**Development Application and Planning Proposal Review
NSW Planning Portal Concurrence and Referral**

Authority	Authority's Reference	Agency Concurrence and Referral	Authority Contact	Authority Notification	Submission Due	Submission Made
NSW Dept. of Planning & Environment	SSD-41589232		Shaun Williams	19/01/2023	16/02/2023	16/02/2023

Address	Land Title
51 Huntingwood Drive, Huntingwood NSW 2148	LOT 1 DP 857249

Scope of Development Application or Planning Proposal
Environmental Impact Statement (EIS) for the 51 Huntingwood Drive Data Centre. Construction and operation of a Data Centre with a total power consumption of 400 MW including demolition, bulk earthworks, associated infrastructure and services, landscaping and car parking.

Figure 7 **Site Access Arrangements**

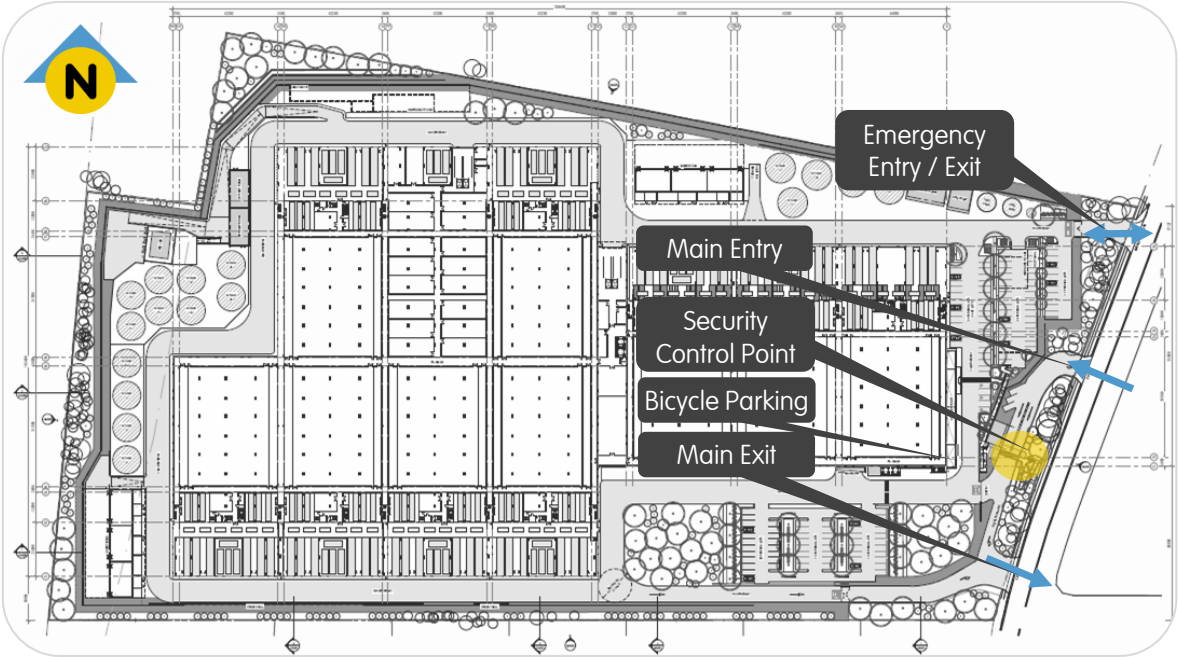
From the following extract of the Overall Site Plan from which the approximate location of the streetlight columns has been overlaid from the Site Plan from Endeavour Energy's G/Net Master Facility Model, it appears the eastern streetlight column is in the new driveway opening / exit.

Either the driveway will need to be redesigned or an application made for Relocation / Removal of Electrical Network Assets to Endeavour Energy's Customer Network Solutions Branch.
